Application Ref:	3/2025/0747			 <p>Ribble Valley Borough Council www.ribblevalley.gov.uk</p>
Date Inspected:	Previously visited for pre-application enquiry 03/04/2025	Site Notice:	06/11/2025	
Officer:	MC			
DELEGATED ITEM FILE REPORT:				APPROVAL

Development Description:	Listed Building Consent for installation of solar photovoltaic panels on existing roofs across the college. Panels to be located on the South Fronts roofs, and West Fronts roof.
Site Address/Location:	Stonyhurst College, Avenue Road, Hurst Green, BB7 9PZ

GA Proposed Plan - South Fronts West

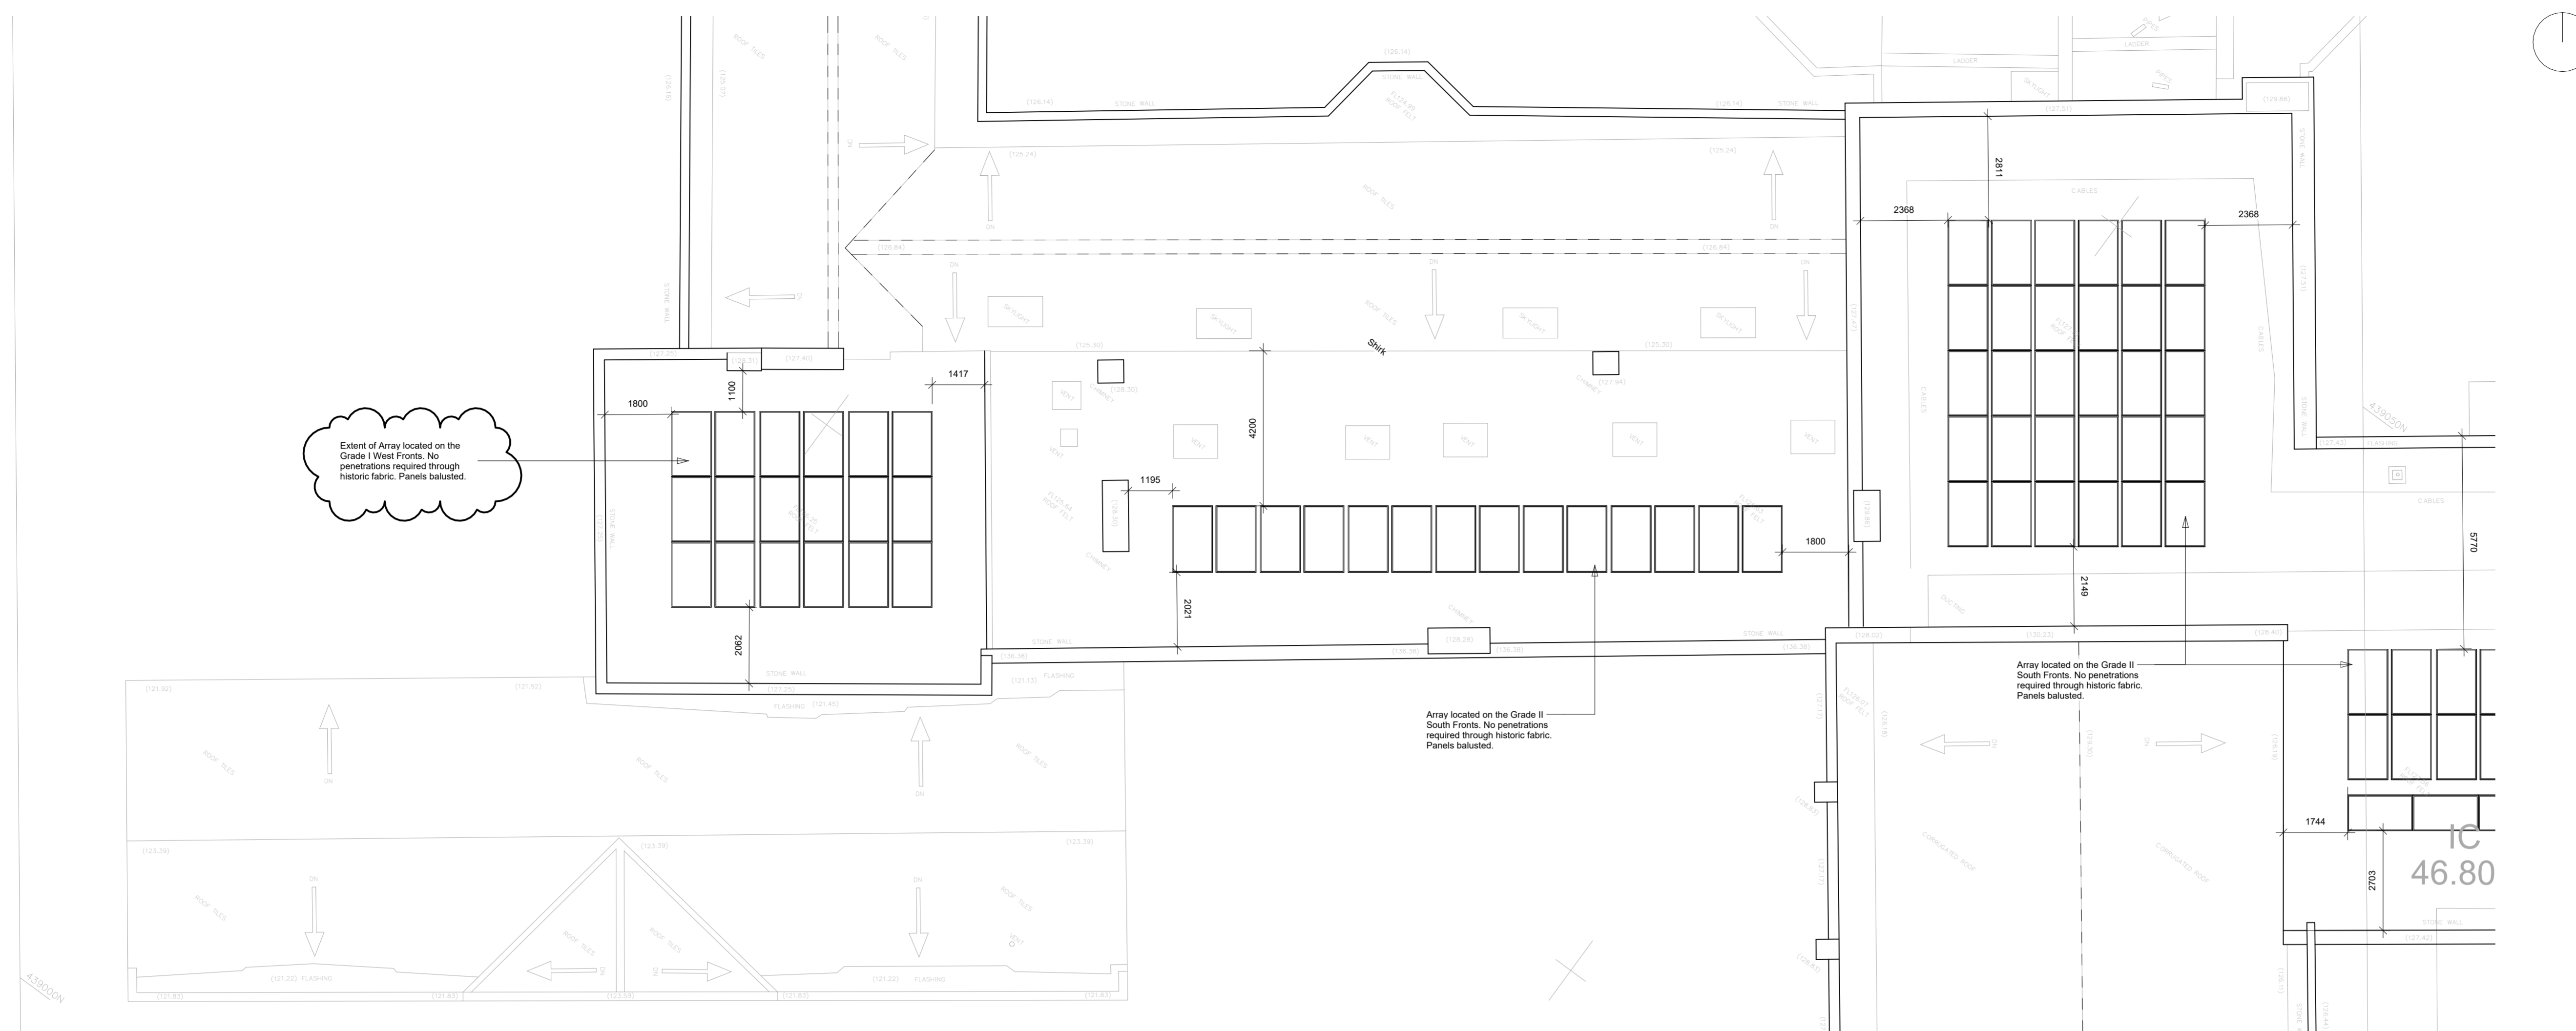
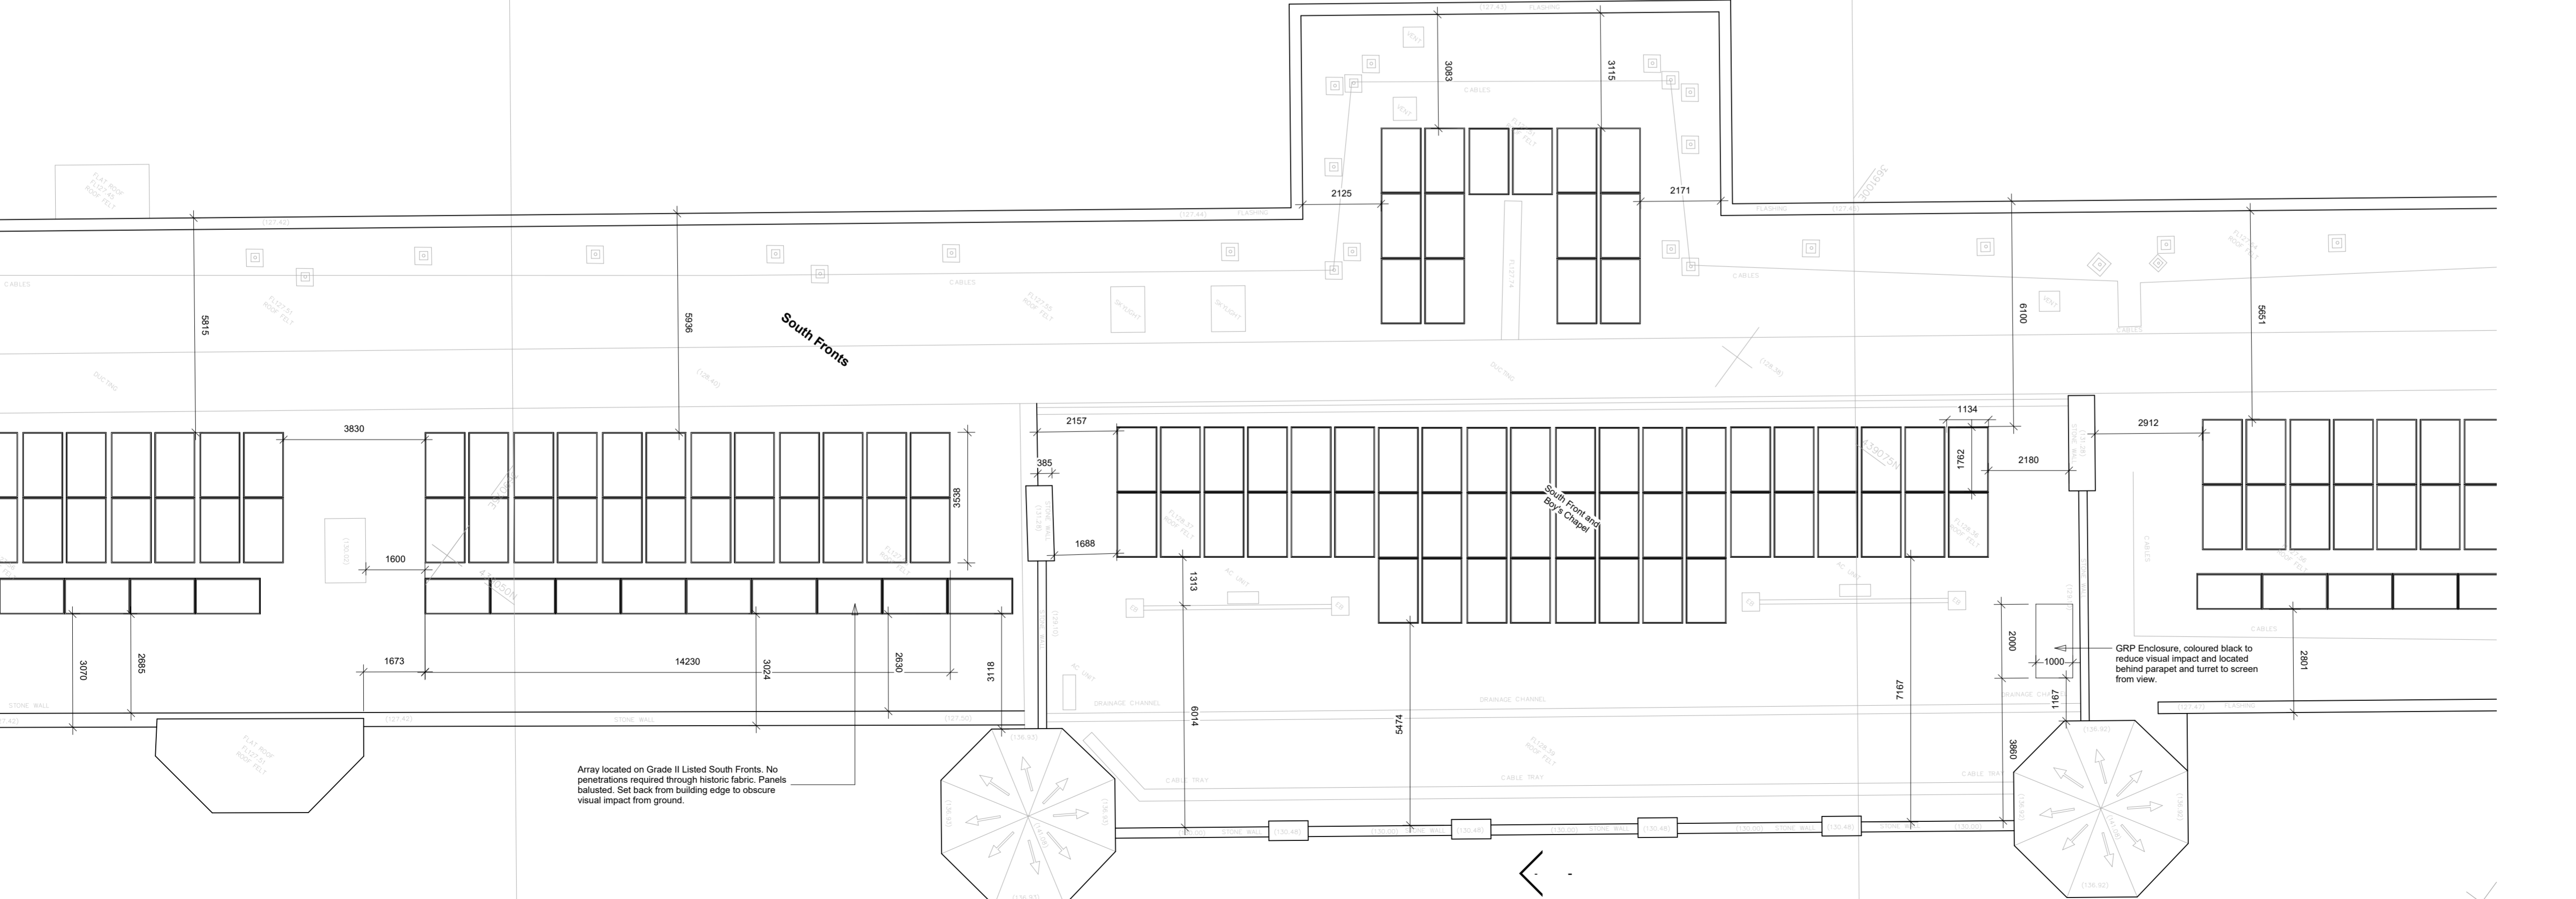
Historic England has provided comments on the scheme and they note that the proposed locations of the PV panels on the listed structures would be on areas of recently re-covered bitumen flat roof. Historic England requested that details and the location of electrical distribution equipment, cabling and inverters are provided to give assurance that there would not be an impact from these on the historic fabric. A structural engineering report was also requested to demonstrate that the very significant historic roof structures on the South Front and on the south range of the West Front can take the additional loads of the panels plus the associated ballast.

Heritage and Conservation Officer at Growth Lancashire also considers that upon viewing the FlatFix Fusion Project Plan and Technical Manual, and conformation from the project architect that the installation of the ballasted system will not penetrate the historic fabric, in terms of potential visual intrusion caused by the installed units, they are satisfied that the PV arrays that are to be set behind the parapets will likely be adequately screened (this includes PV1, PV4, PV5 and parts of PV7).

Previous concerns were raised at the pre-application stage by the Heritage and Conservation Officer in relation to the left and right extremities of the roof that do not have a parapet border and may be visible from across the raised ornamental gardens to the SE and the square section directly behind the Boy's Chapel which is potentially visible when approaching the college from the SW main driveway and across the ground north of the ponds. They note that the Landscape and Visual Assessment provides a comprehensive evaluation on the areas raised above and they are satisfied that the panels PV3 and PV6 would be set back and at a height that will not be visible anywhere from the grounds to the SE. Whilst the panels PV2 would be somewhat exposed and potentially visible when approaching along the main drive from the SW, the Heritage and Conservation Officer accepts that any visibility will be barely discernible due to the distance and then completely out of view at a distance where they may be discernible.

As such, updated elevations and roof plans showing the location of the GRP enclosure and cabling have been submitted, as well as loading appraisals for each building that is to have solar panels installed to ensure that the buildings can withstand the weight of the solar panels. The loading appraisals confirm the loadings of the solar panels are acceptable and the proposed solar panels can safely be installed onto the existing roof structure with no strengthening works being required.

Whilst the Victorian Society have not commented further on the additional information, Historic England raise no objection on heritage grounds to the scheme and are satisfied that the historic roofs can take the additional loading.

Drawing  
**Proposed South Front Elevations - Middle**

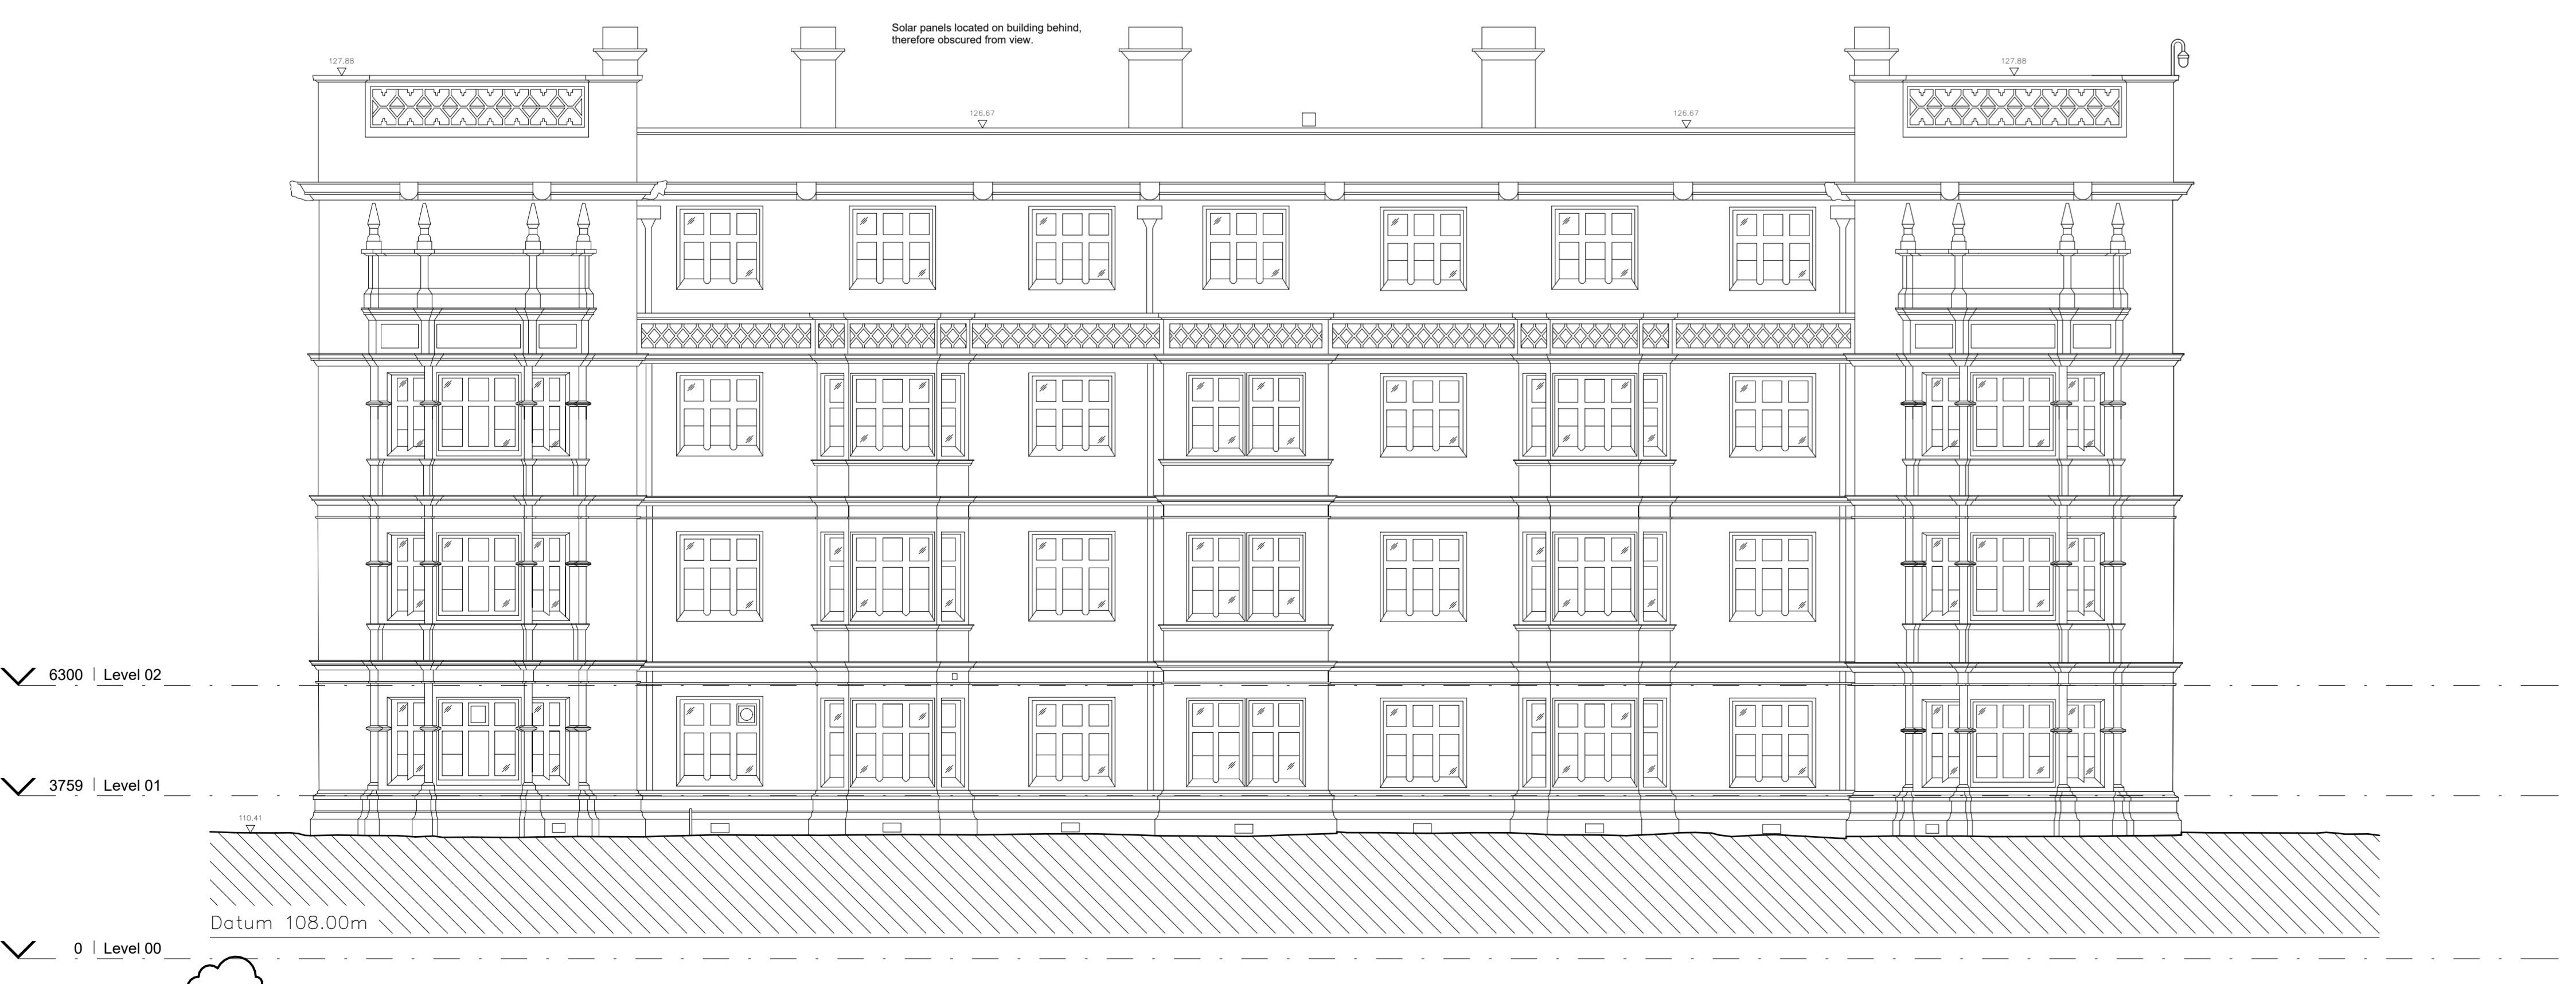
With regards to the visual impact on the listed buildings, Historic England note that the panels have been positioned in a way that avoids visual impact or harm to the special interest of the listed building. The

They conclude that whilst the visual impact has been suitably addressed and will be low to none overall, by virtue of the installation of the 'alien' feature of PV panels to the Grade I listed Old Quadrangle and the Grade II* listed South Front, the harm to its significance is a low level of less than substantial.

Historic England conclude that the location of the solar PV panels would not result in negative visual impacts on the special character of the highly graded listed buildings and therefore support the principle of the installation of PV panels.
